Recommendation Report for Planning Permission for Works or Extension to a Dwelling

REF NO: M/147/21/HH

LOCATION: 19 Elm Drive
Elmer
Middleton-On-Sea
PO22 6JE

PROPOSAL: Single storey rear extension and addition of a storey.

PROPOSED FIRST FLOOR PLAN

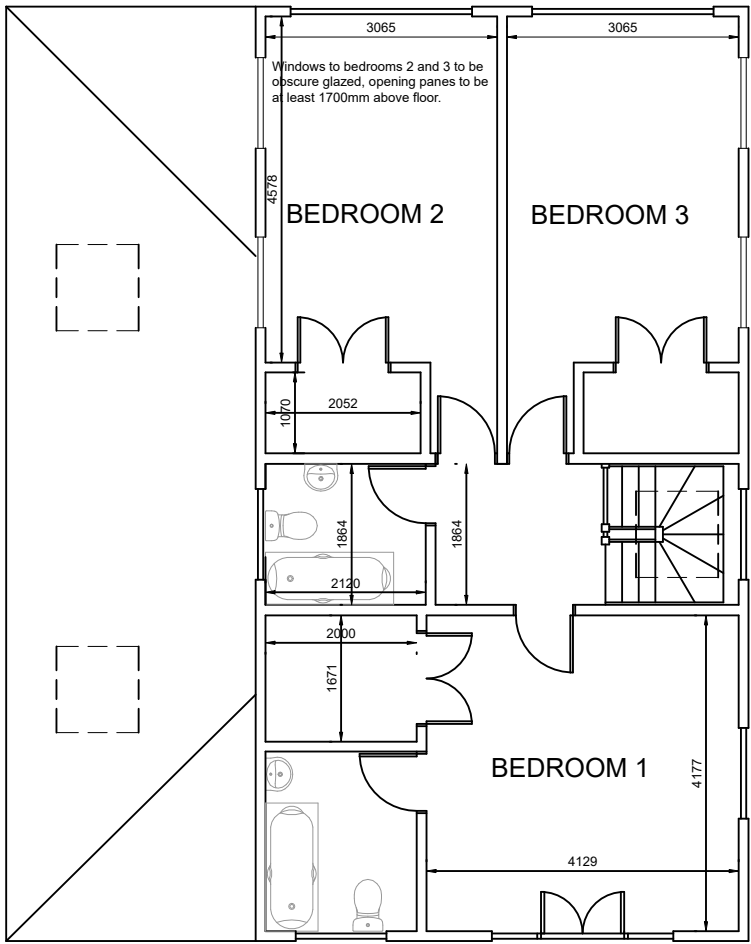
The proposal was revised to redesign the two rear facing windows at first floor to be obscure glazed, opening panes at least 1.7m above floor, will not result in overlooking neighbour's garden at 17 and 21 Elm Drive and will not result in loss of privacy. The development will not project beyond the original rear elevation and the separation distances between properties are maintained. A neighbouring property (13 Elm Drive) was recently approved a two storey replacement dwelling with rear window.

The proposal was revised to incorporate two first floor side windows on each side which will serve each bedroom but will be high level windows for natural daylight. Another first floor side windows leads to the stairwell to provide natural daylight couple with roof light. There is another first floor high level side window serving a toilet and bathroom on the other side of the development closer to 21 Elm Drive to provide natural daylight. Due to the design and positioning of these floor first side windows, they will not result in overlooking and loss of privacy. In the light of these, the rear and side windows at first floor are not considered to result in significant overlooking and loss of privacy on neighbouring occupiers to justify refusal.

- 4 The two proposed first floor rear elevation windows shall be obscure glazed up to a height of 1.7m above the floor of the room in which the window is installed and non-opening unless the parts of the window which can be opened are more than 1.7m above the floor of the room in which the window is installed.

PROPOSED ROOF PLAN

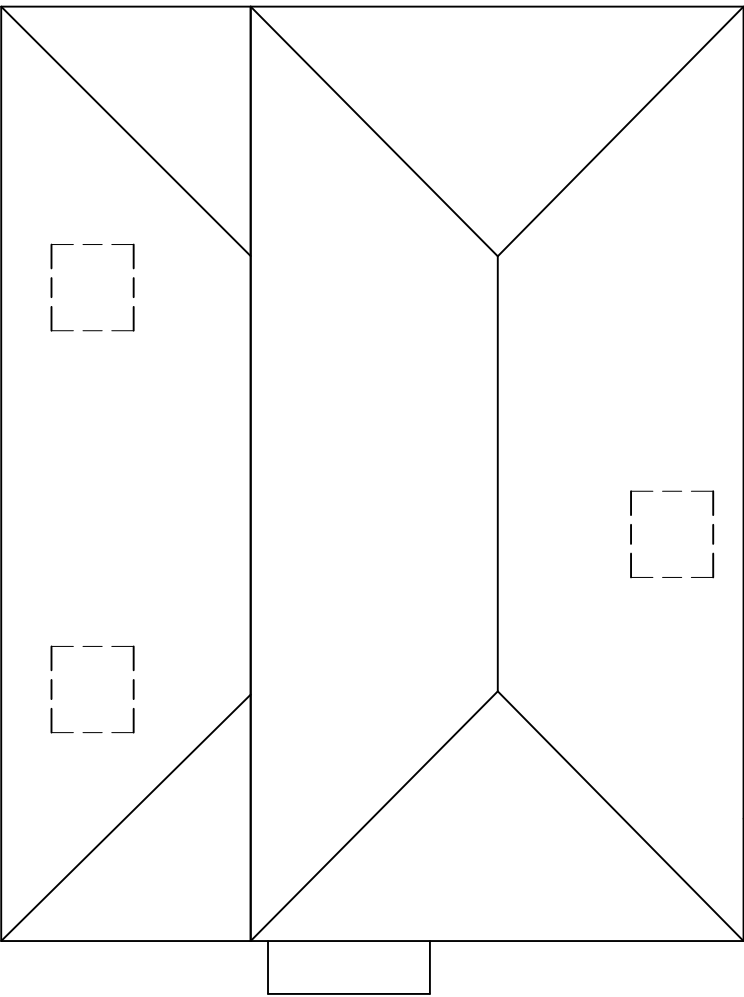
Given the concerns about overlooking it would be appropriate to restrict via condition additional extensions to the new roof in the form of dormer windows.

- 5 Notwithstanding the provisions of Part 1 of Schedule 2 of the Town and Country Planning (General Permitted Development) (England) Order, 2015 (or any Order revoking or re-enacting this Order) no roof extensions (including dormer windows) shall be constructed to the approved roof unless permission is granted by the Local Planning Authority on an application in that behalf.
